KIRKLEES METROPOLITAN COUNCIL INVESTMENT & REGENERATION SERVICE

DELEGATED DECISION TO DETERMINE APPLICATIONS FOR CONSENT, AGREEMENT OR APPROVAL REQUIRED BY CONDITION

Reference No:	2025/44/90352/E
Site Address:	adj, 33a, Church Lane, Clayton West, Huddersfield, HD8 9LY
Description:	Discharge of details reserved by conditions 6 (boundary treatments), 8 (intrusive site investigations and remedial works), 9 (declaration), 10 (Phase I Desk study Report), 11 (Phase II Intrusive Site Investigation Report), 12 (Remediation Strategy), 13 (Remediation Strategy), 14 (Verification Report) and 15 (Arboricultural Method Statement and Tree Protection Plan) of previous permission 2024/93464 for variation condition 2 (plans) on previous permission 2023/91483 for demolition of garage and erection of detached dwelling.
Recommending Officer:	Elenya Jackson

DECISION – APPROVE DISCHARGE OF CONDITION 6

Boundary Treatment Plan

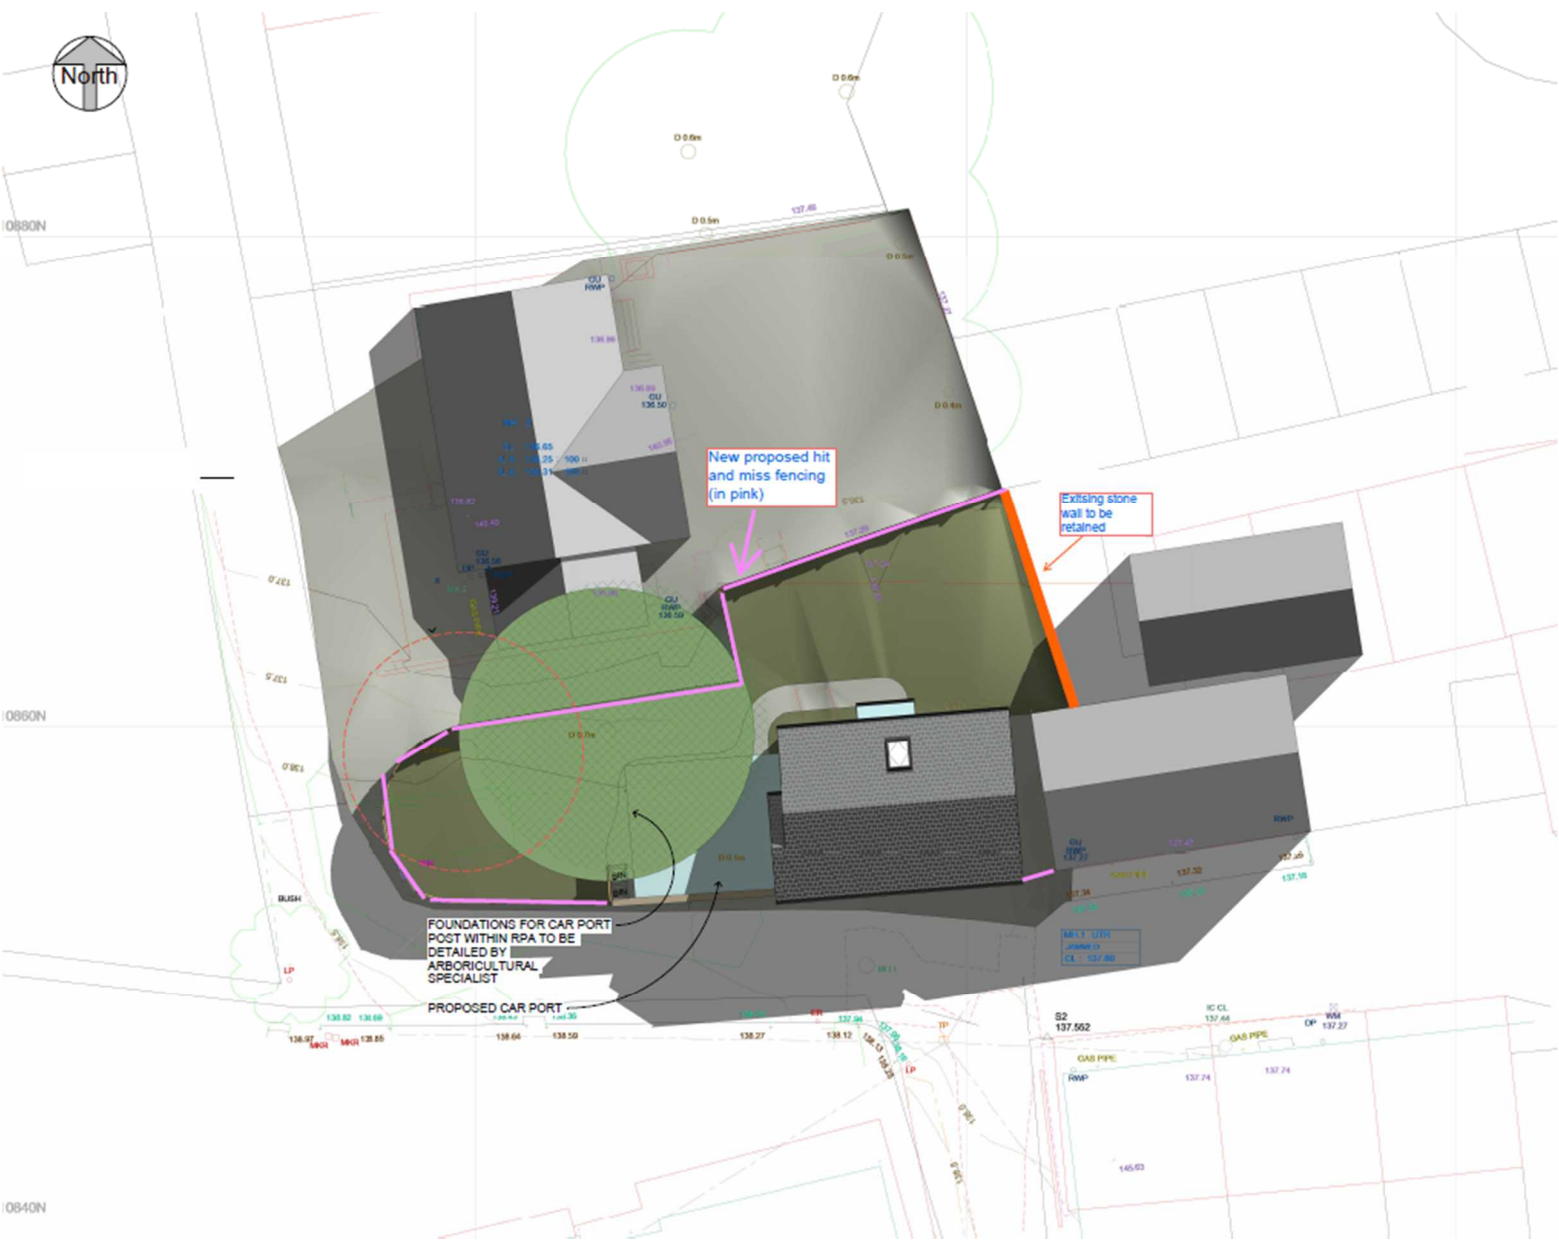
Officer have previously raised concerns regarding the height of the proposed fence adjacent to the access with both the parking area for the approved dwelling and the existing access to 33a Church Lane. Officers had asked applicant to demonstrate visibility splays on the plans to demonstrate that this would not interfere with visibility however this has not been provided. Similar details were submitted and refused under application 2024/93179. The officer report for this application stated “a 1.8m fence adjacent to a vehicular access would not be acceptable as it would raise concerns relating to visibility.”

The amended document shows a 1m fence to the side of the dwelling which would not raise concerns regarding visibility splays and would therefore be considered acceptable.

The details are therefore considered acceptable for the purpose of condition 6 and shall be retained as such for the lifetime of the development.

Remediation Plan

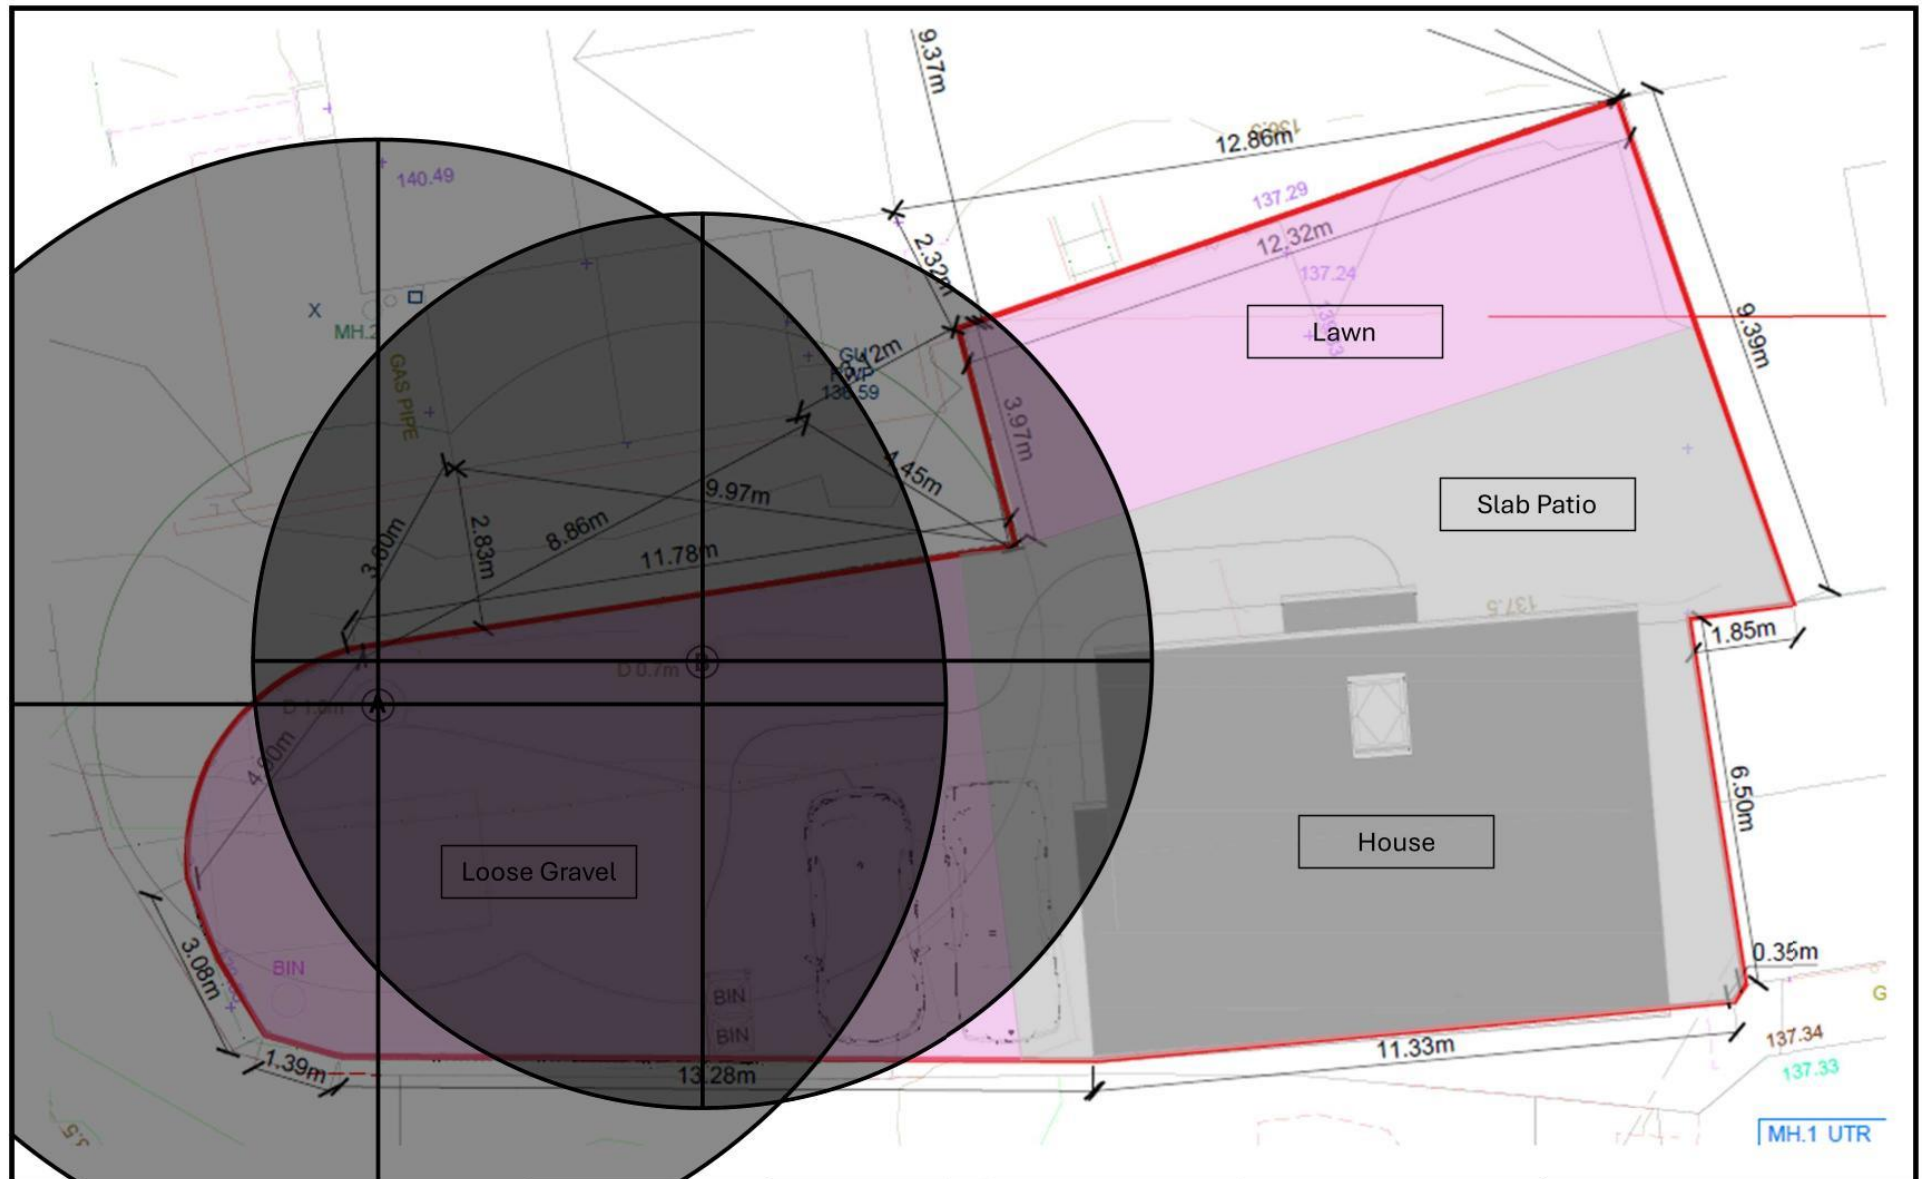
We note in the Remediation Plan, appendix 1, the 300mm of clean cover proposed is extended to the entire soft landscaped areas and not just areas identified as tree root protection zones.

We do not accept the Remediation Strategy Report by Geoinvestgate, dated April 2025, ref: G24327, the 300mm clean cover depth in soft landscaped areas may be insufficient to ensure there is adequate protection for end-users. We therefore request that the contaminated land consultant provide further information to address these concerns.

Additional risk assessment, GI or revised proposals may be necessary. This must be undertaken by a competent person as defined in the NPPF. Any new information must confirm, to a high degree of confidence, that the remediation strategy will ensure adequate protection for end users.

Appendix 2 Tree Protection Plan

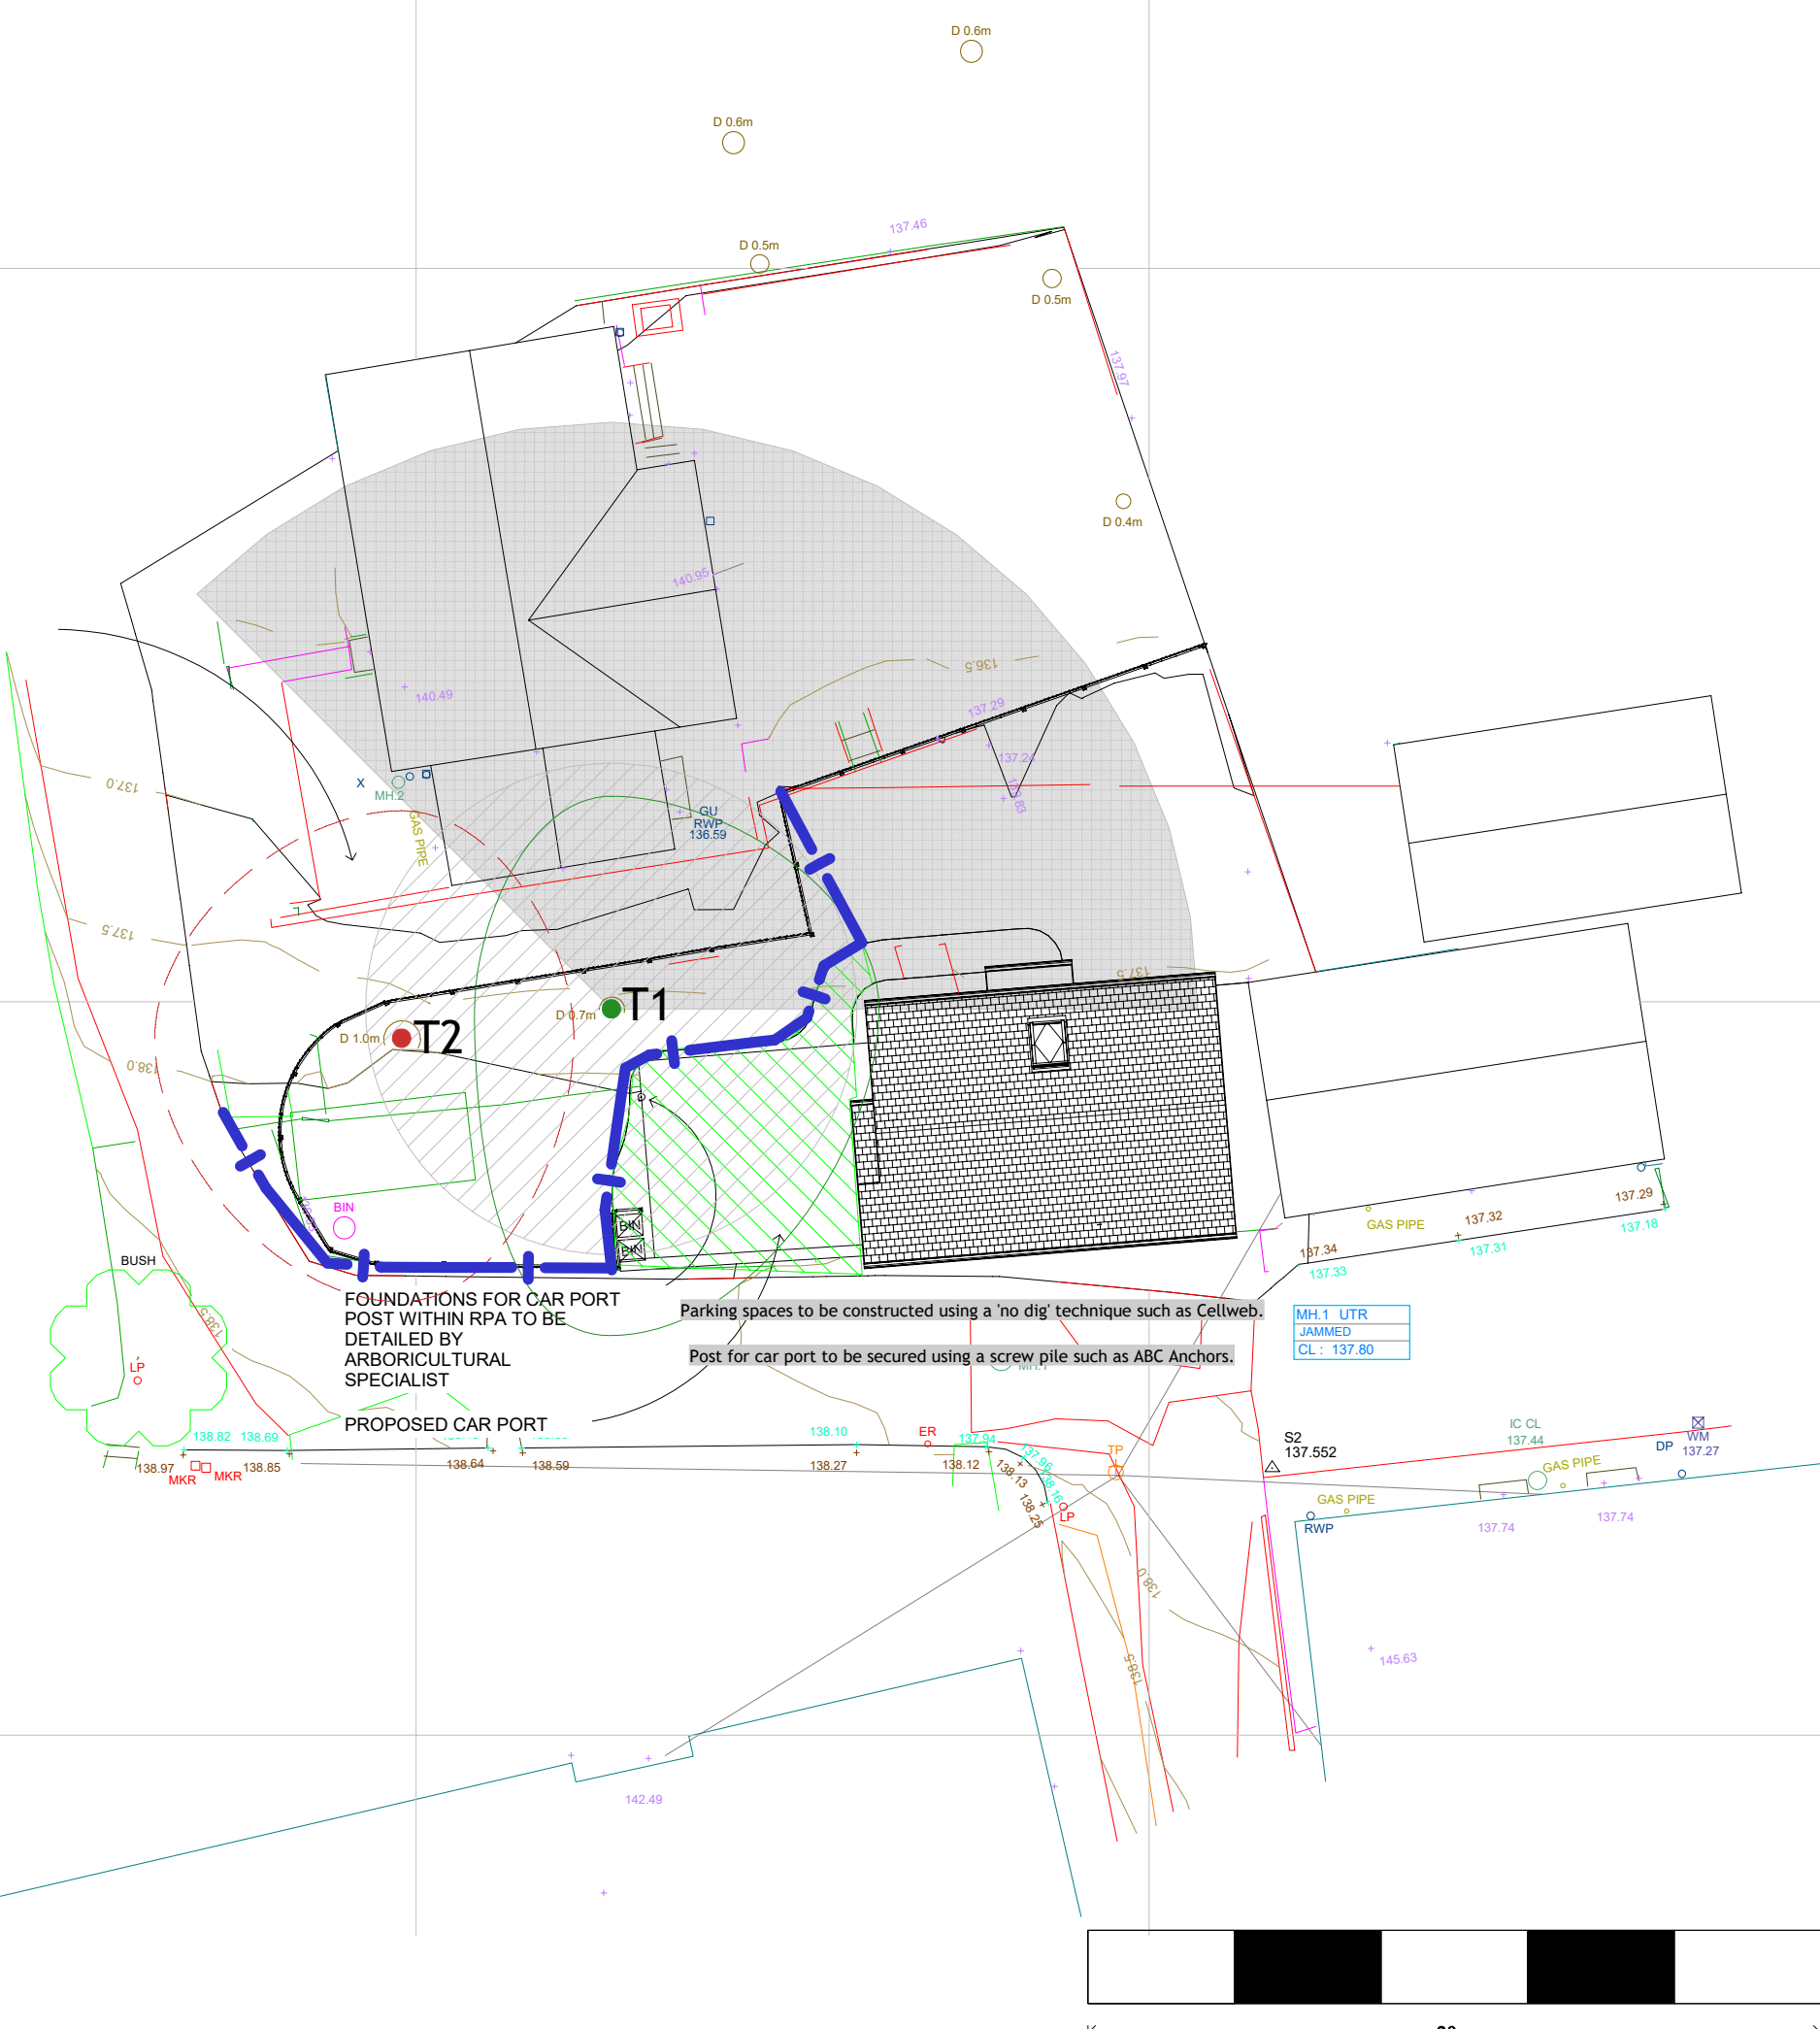
However, officers have reviewed the planning history on site and understand that T2 was agreed to be removed as part of the previous approval and therefore the submitted document Roavr Group 25_5837_07_112 contains inaccuracies as T2 has been removed on site.
